From: Elaine Walby on behalf of Planning.Responses
Sent: 22 June 2026 16:04
To: Planning Scanning
Subject: FW: Application CM/6/26/PL - Caravan Storage, Church Barn, Climping

PL- Consultation- WSCC Public Rights of Way response

From: Darryl Hobden [REDACTED]
Sent: 17 June 2026 09:32
To: Hebe Smith <Hebe.Smith@arun.gov.uk>
Subject: RE: Application CM/6/26/PL - Caravan Storage, Church Barn, Climping

DRAWING TITLE	
HORSEMER GREEN LANE, CLYMPING. BN17 5QX.	
DRAWING TITLE	
BLOCK AND LOCATION PLANS	
SCALE	DATE
1:500 & 1:1250 @ A1	DEC. 2025
DRAWING NO.	
25/639-01

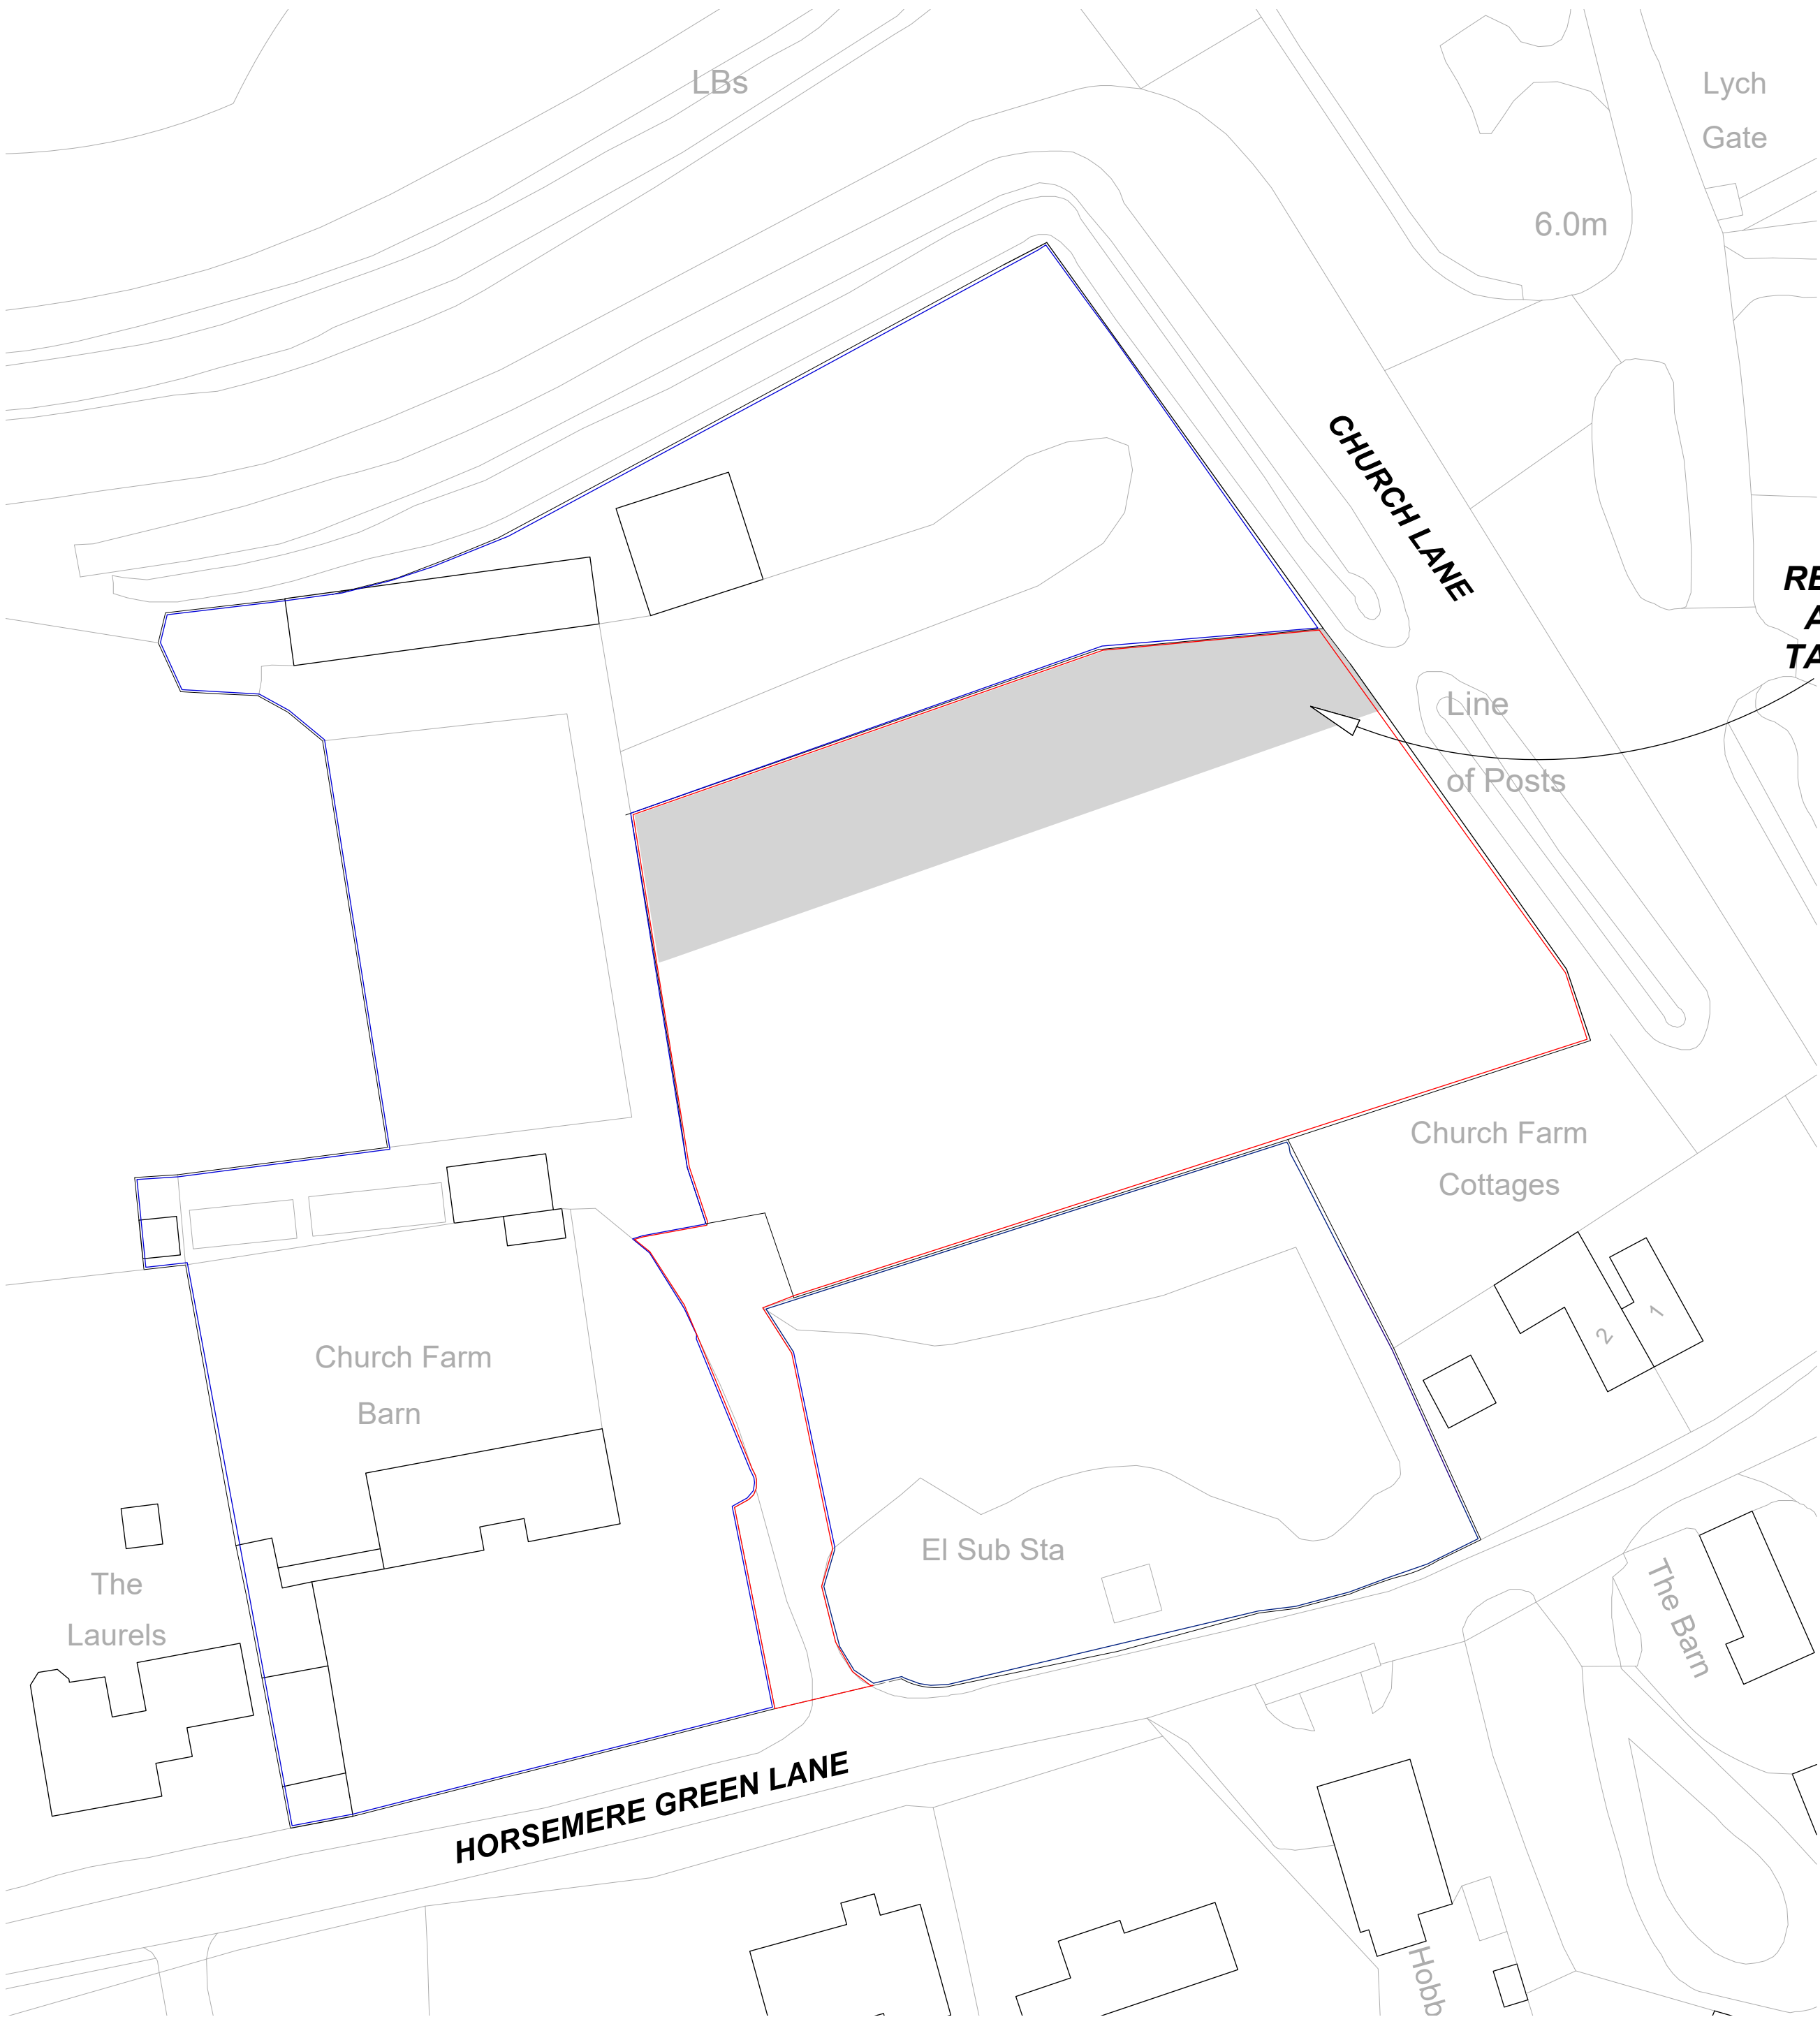
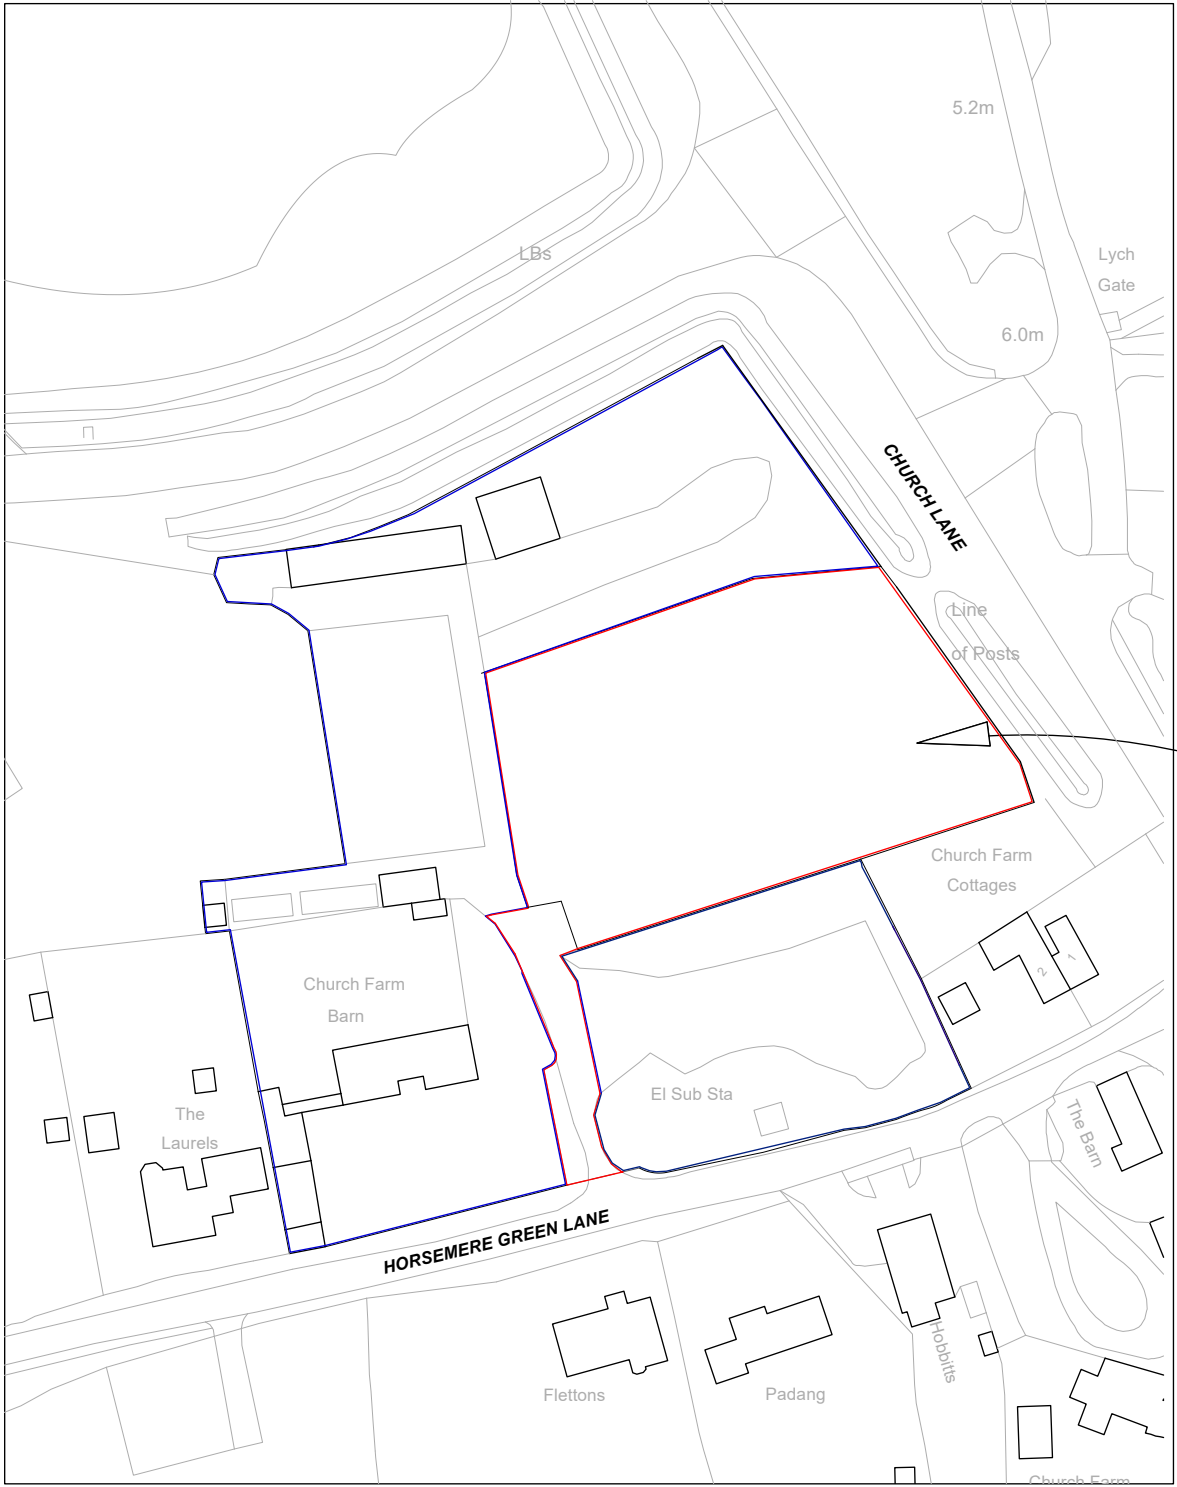
For the avoidance of doubt the applicant is well aware of the legal definitive line of Footpath 175, however provided an 'alternate' option for users which is the one you describe. This alternate route has no legal basis, however due to ongoing obstruction of the footpath, the permissive option was installed some years ago by the owner. Despite numerous correspondence, the matter has been a low priority for WSCC given the alternate route provided, however the legal line must be accommodated in these plans.

As it stands the objection will remain until such time that the applicant can either accommodate the Public Footpath as per its legal line, or apply for the diversion as part of the planning application under s.257. It should be noted that a minimum 2m width would be expected for the Footpath, however any plans would be reviewed by this department.

A s.257 Town and Country Planning Act diversion may be considered by the applicant and yourselves, which would formalise the situation and for which you would process, with WSCC as a consultee.
